Recommendation Report for Planning Permission for Works or Extension to a Dwelling**REF NO:** EP/95/14/HH**LOCATION:** 91 North Lane
East Preston**PROPOSAL:** Demolition of existing garage (front), side entrance & toilet (single storey) & rear conservatory. New single storey garage & front porch. Single storey extension to west elevation & single & double storey rear extension. Resubmission of EP/144/13/**SITE AND SURROUNDINGS**

This application seeks planning permission for a two storey rear extension and single storey side extension on the property, a portion of which will extend to the front and will be the only change to

PL111

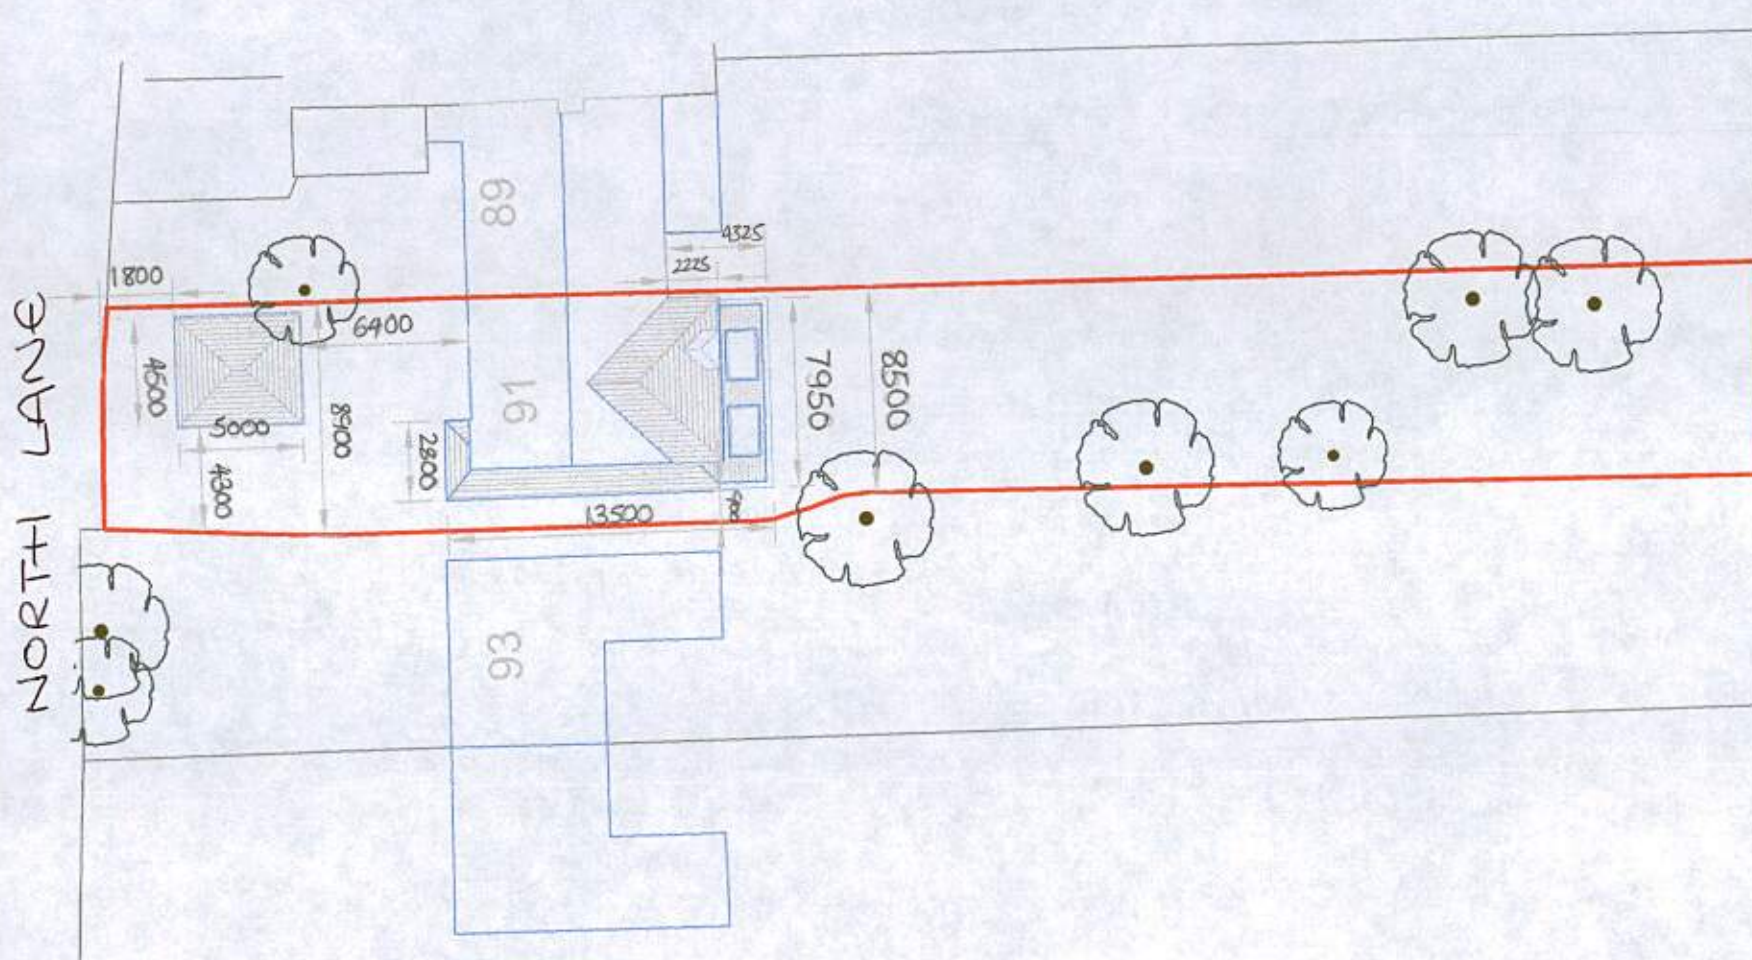
*Inaccurate plans as 89a is not shown to its full length which is approximately 9m and a single storey building with windows all the way down the side facing the proposed extension next door.

2001-1	PL0109	A
--------	--------	---

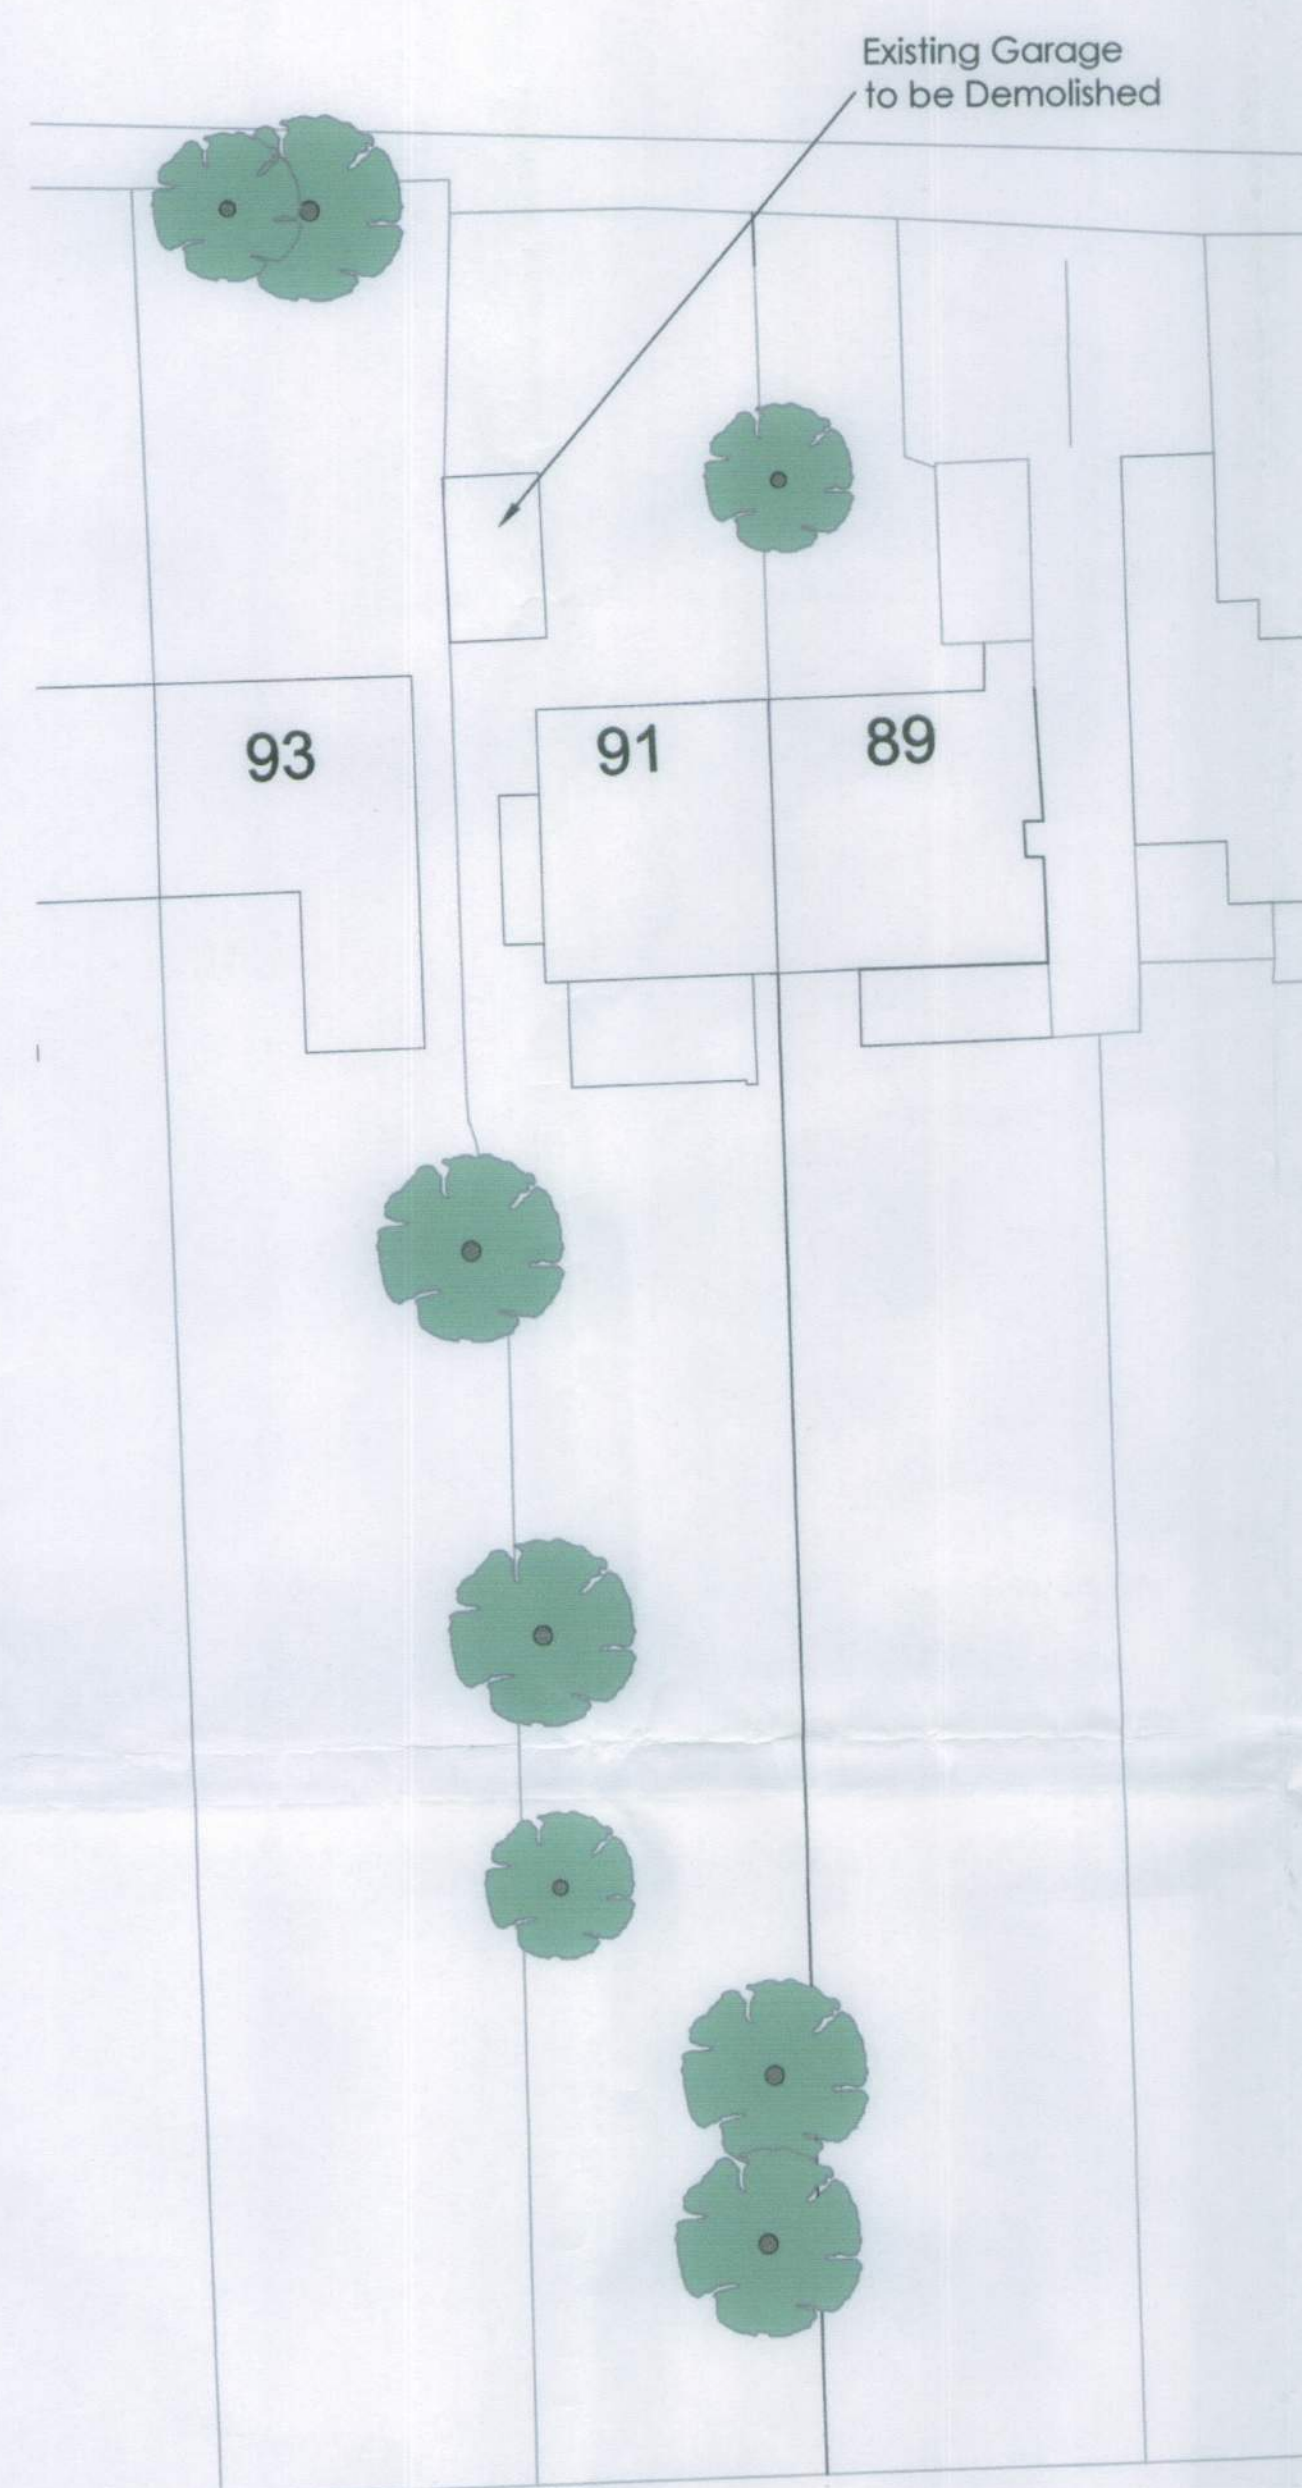
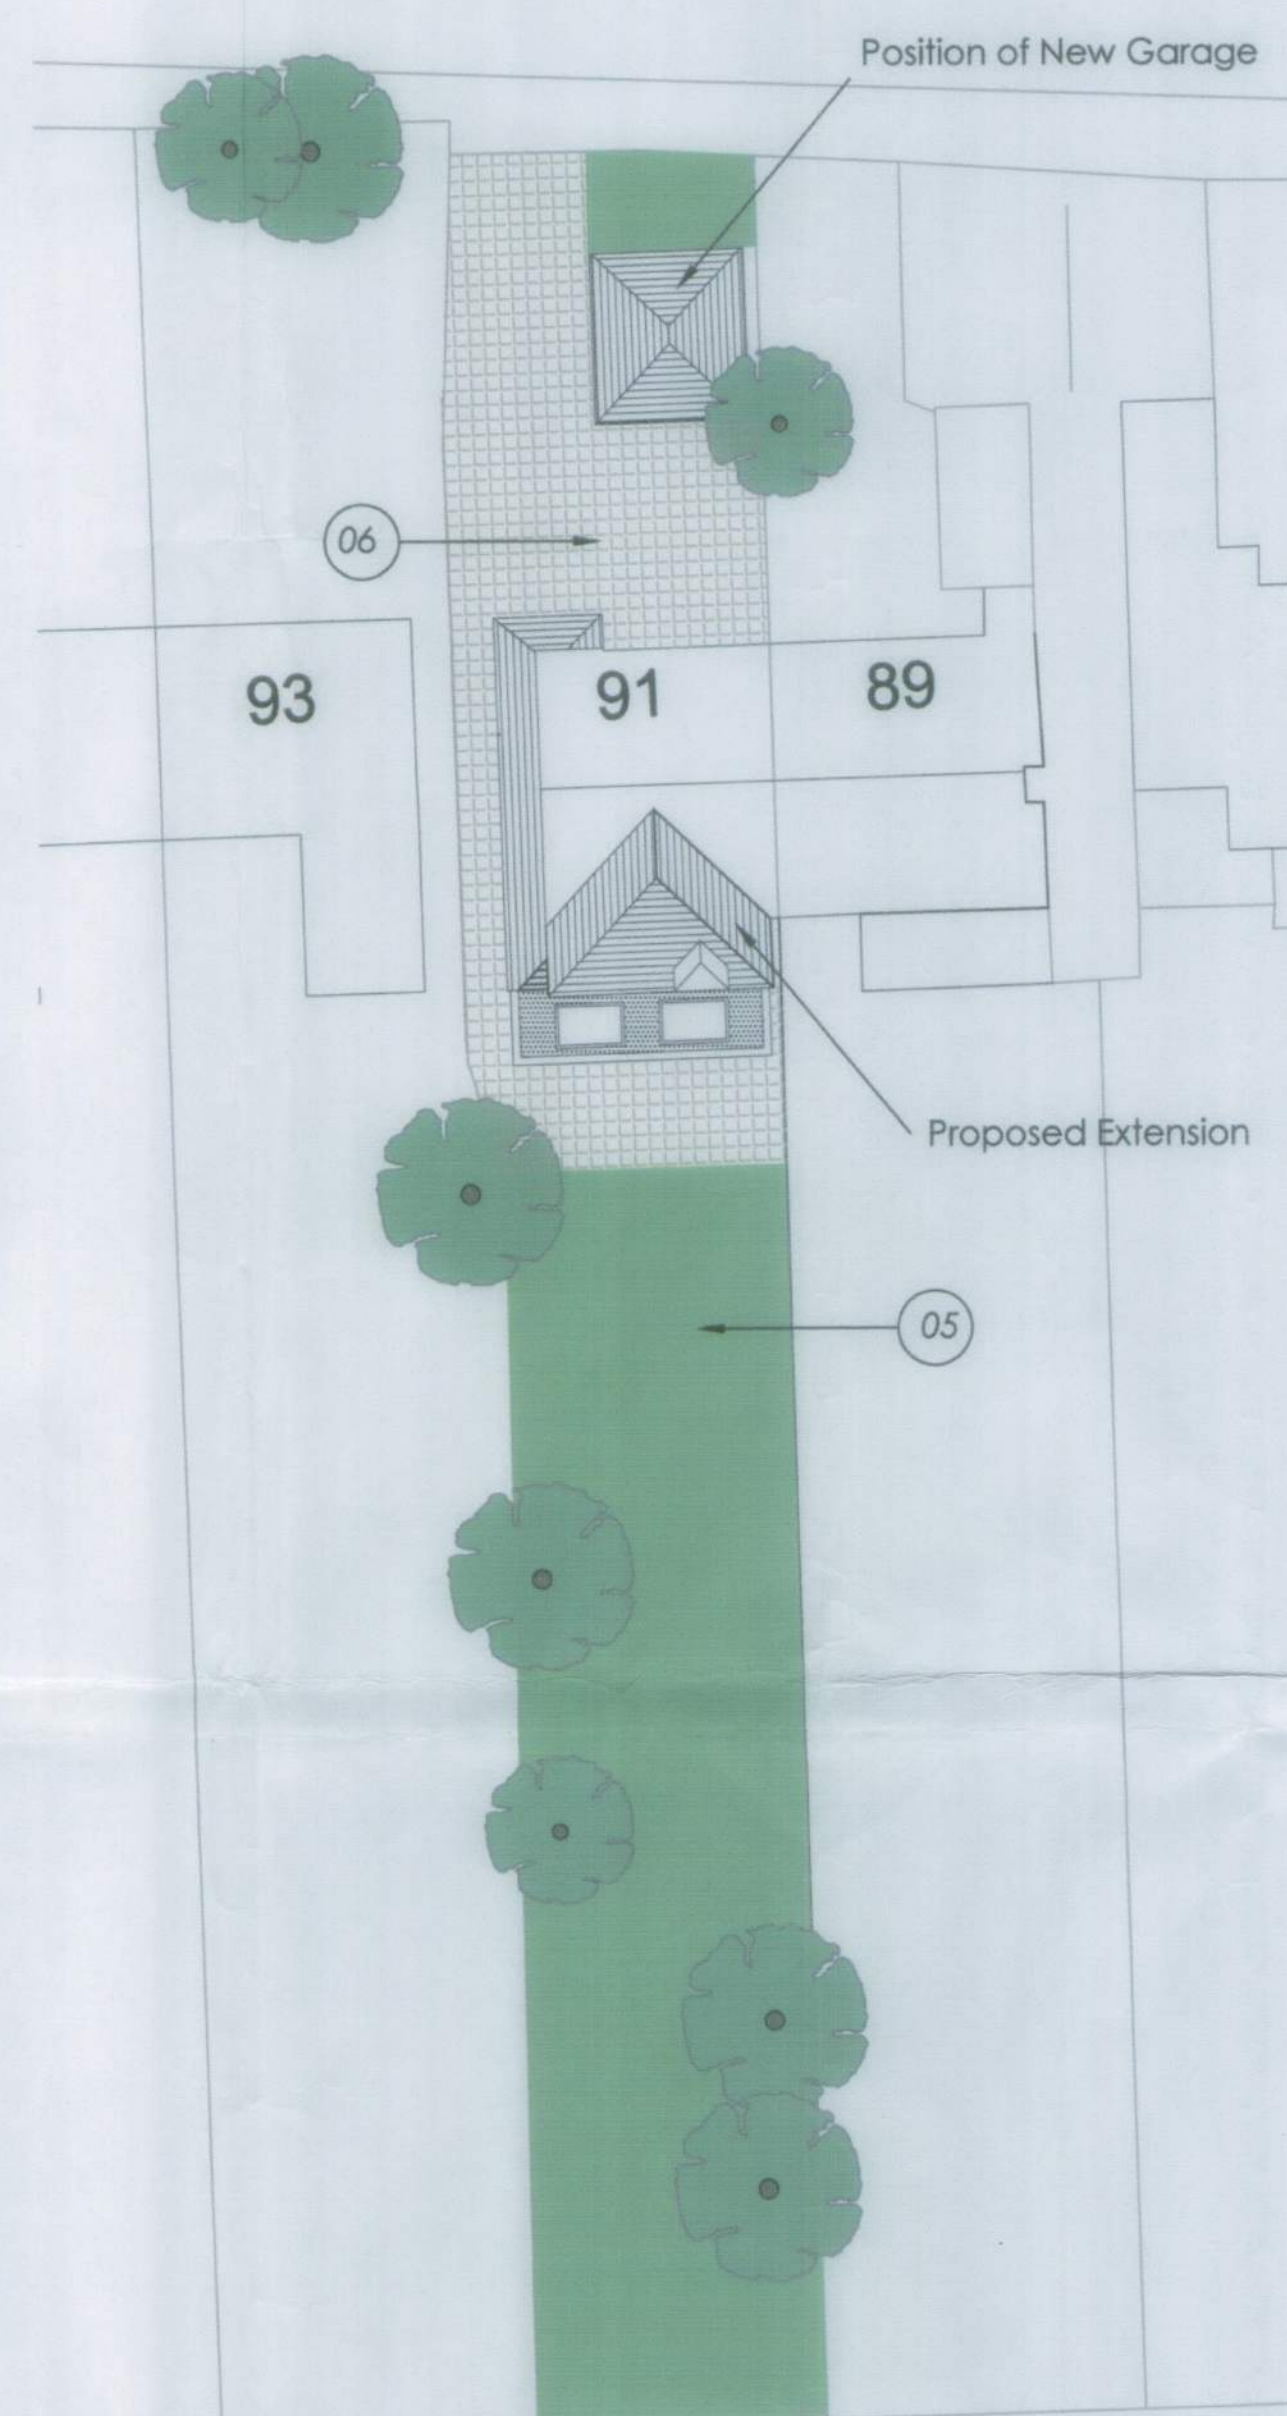
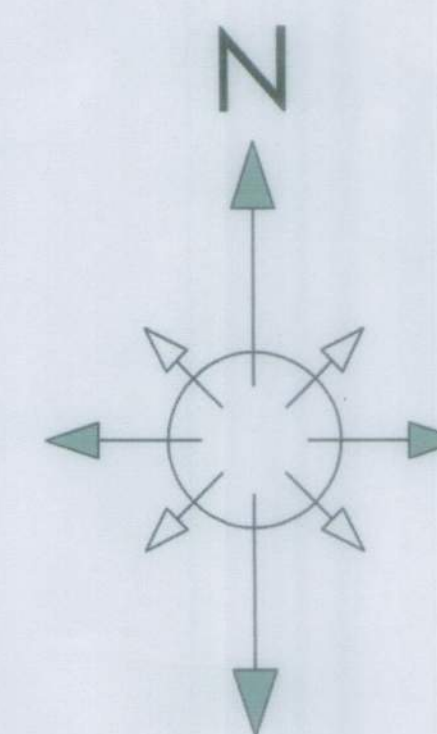
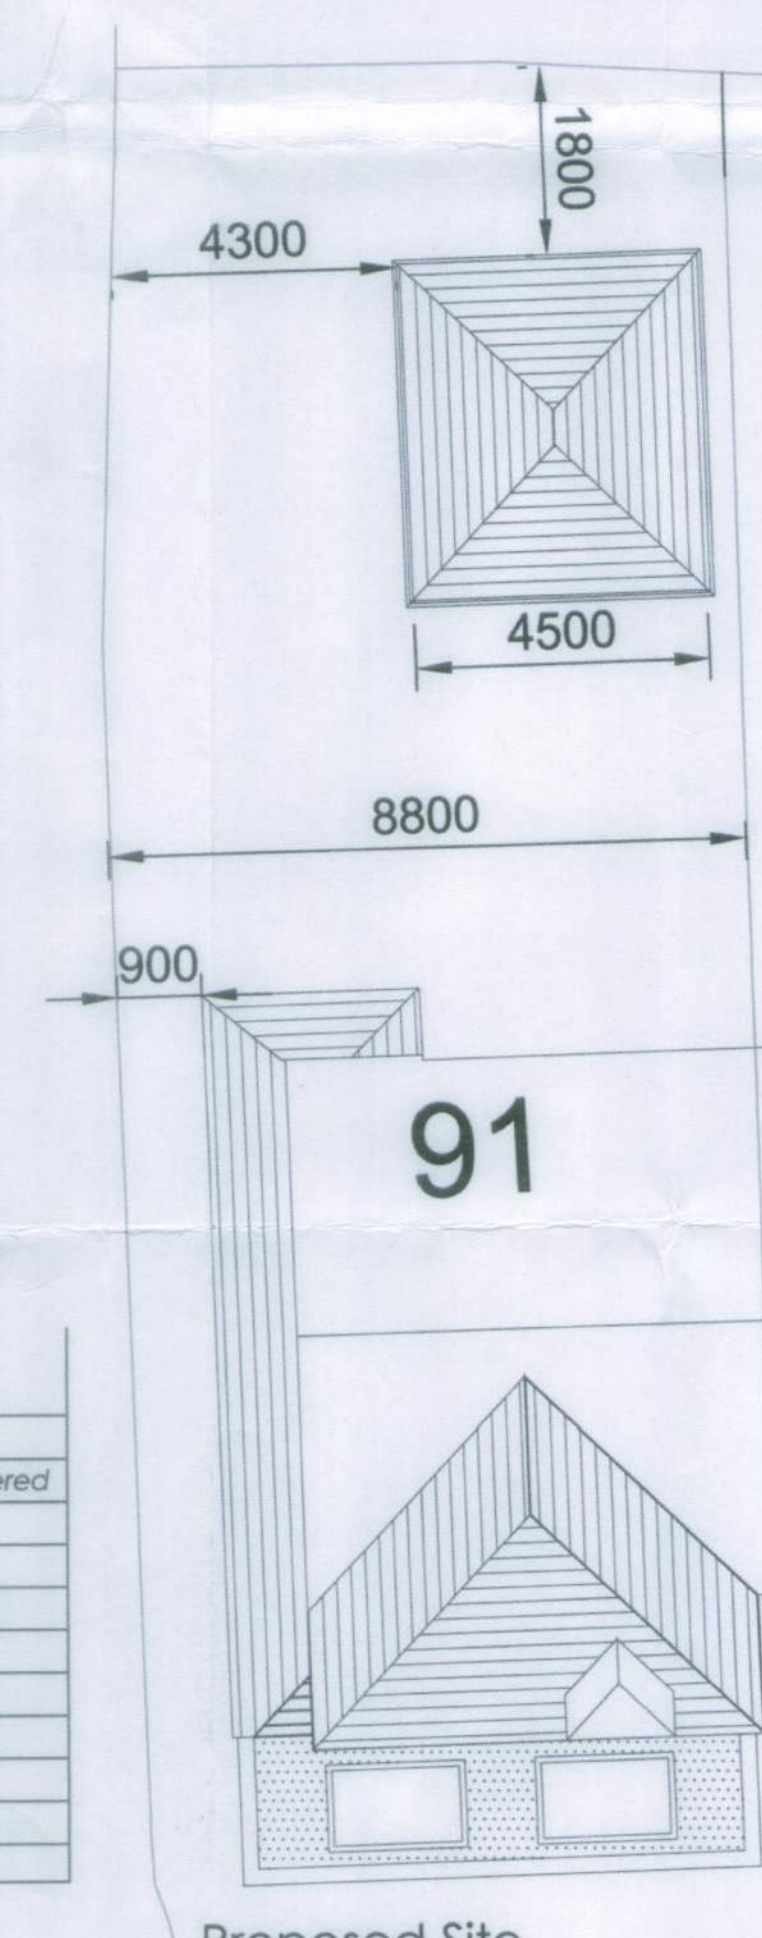
In respect to the proposed garage, there are a number of detached garages situated forward of dwellings in North Lane and on the same side of the road as the application site, most notably at nos. 87 and 89. It is therefore considered that the detached garage will not appear harmfully out of character with its surroundings. An existing garage closer to the property will be demolished through this proposal so that the front garden is not taken up with such development. In order to soften the appearance of the detached garage, a condition requiring the retention of the existing hedge/tree screening to the front and additional proposed landscaping to the front is proposed with the recommendation.

The proposed garage will be situated approximately 6.5m away from the neighbouring property of no. 89 North Lane to the east. This is considered to be a sufficient distance away so as to not cause any overbearing or overshadowing effects. Despite its close proximity to the eastern boundary at approximately 0.2m, the height to roof level at approximately 2.3m in height will not be significantly above the boundary fence line at approximately 1.8m in height and with trees and a detached garage at no. 89 nearby will combine to mitigate any adverse effects that may arise.

- 5 No development shall take place until there has been submitted to and approved by the Local Planning Authority details of the landscaping to be planted in the north-east corner of the site in front of the detached garage hereby approved. The details so approved shall be carried out in the first planting season following the completion of the development and shall be retained at all times thereafter.
